**Re: Planning application 2024/62/92394/E**

**Development of an attenuation basin and associated access relating to planning permission 2021/92801 at Land at Merchant Fields Farm, Off Hunsworth Lane, Cleckheaton**

**The Coal Authority response: SUBSTANTIVE CONCERN**

**VEHICLE TRACKING LAYOUT
ATTENUATION BASIN**

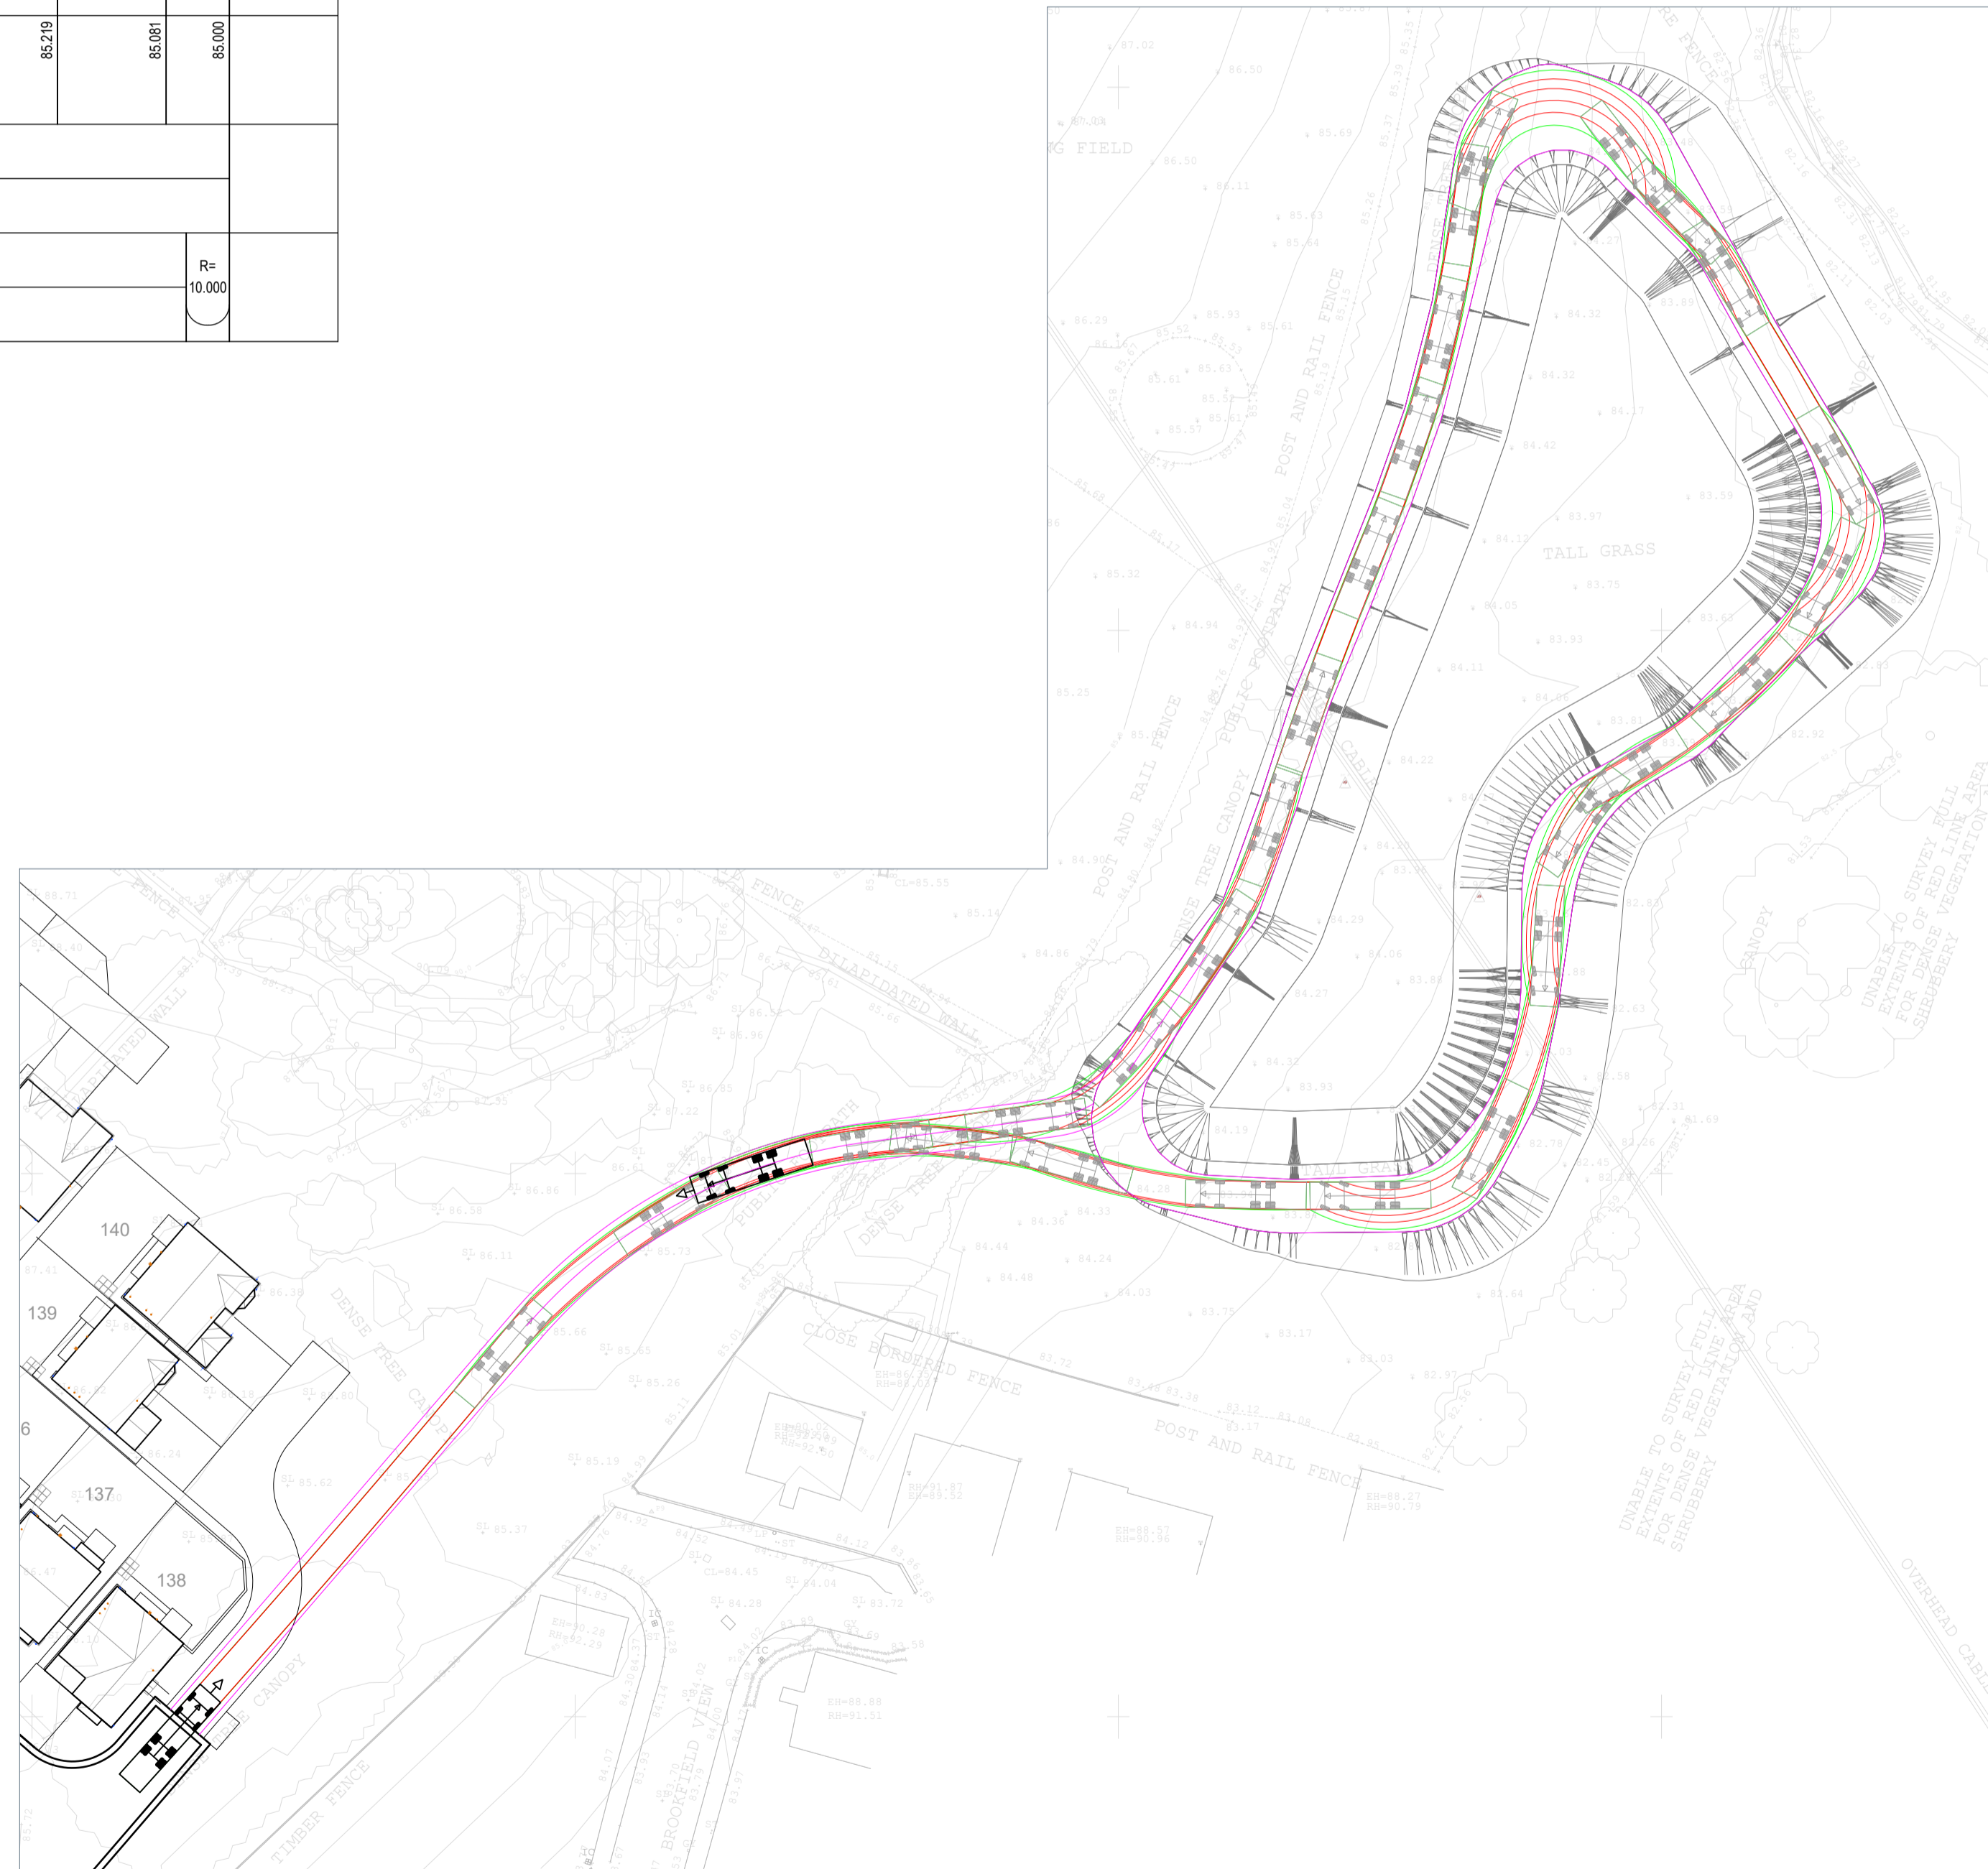
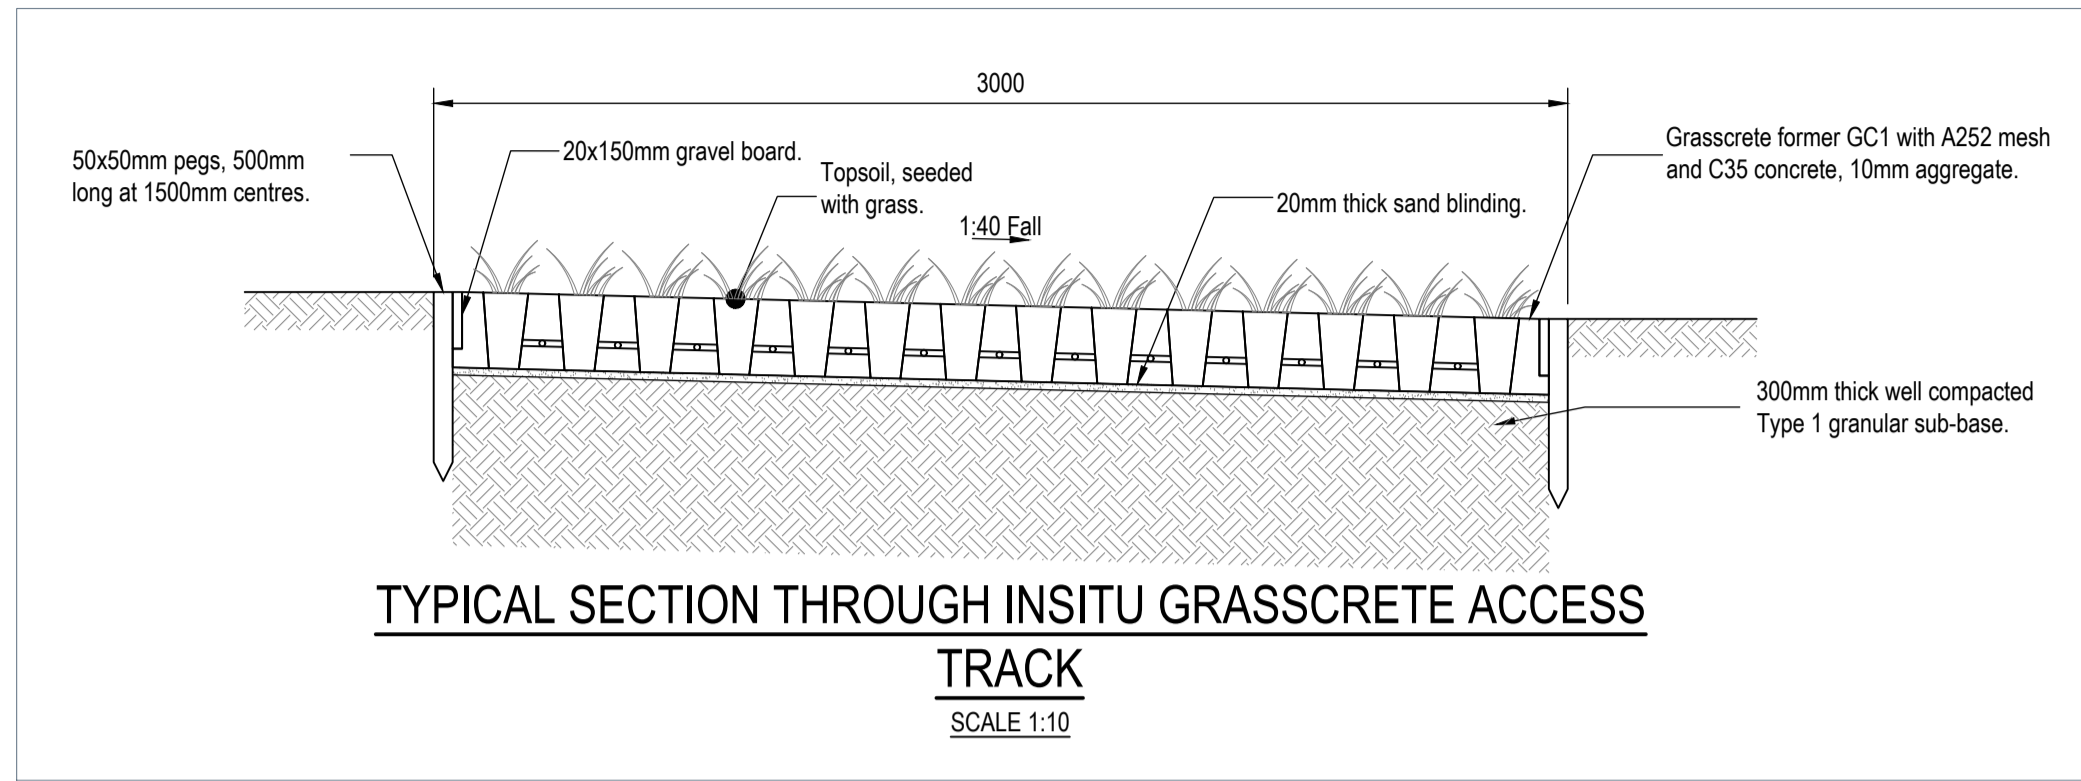
However, our primary concern with the submitted report is that it has been produced solely to inform the attenuation basin element of the proposal. It does not provide any assessment of the risks posed by coal mining legacy to the proposed access route extending from the new estate street to the basin, which would appear to pass directly over shaft 419426-005 and within the zones of influence of shafts 419426-001 and 419426-002.

We consider that efforts should be taken to revise the access route where possible to avoid the recorded mine shafts and their associated zones of influence. If this is not possible, clear reasoning should be provided, along with an outline as to how the safety and stability risks posed by coal mining legacy, particularly the mine shafts, is to be appropriately addressed. The required report should include a proposed site plan clearly showing the positions of the mine shafts and the extent of their associated zones of influence relative to the proposed development.

**The applicant should be advised of our objection and requested to submit a further Coal Mining Risk Assessment, or equivalent report, which assesses the risk posed by coal mining legacy to all elements of the proposed scheme of development.**
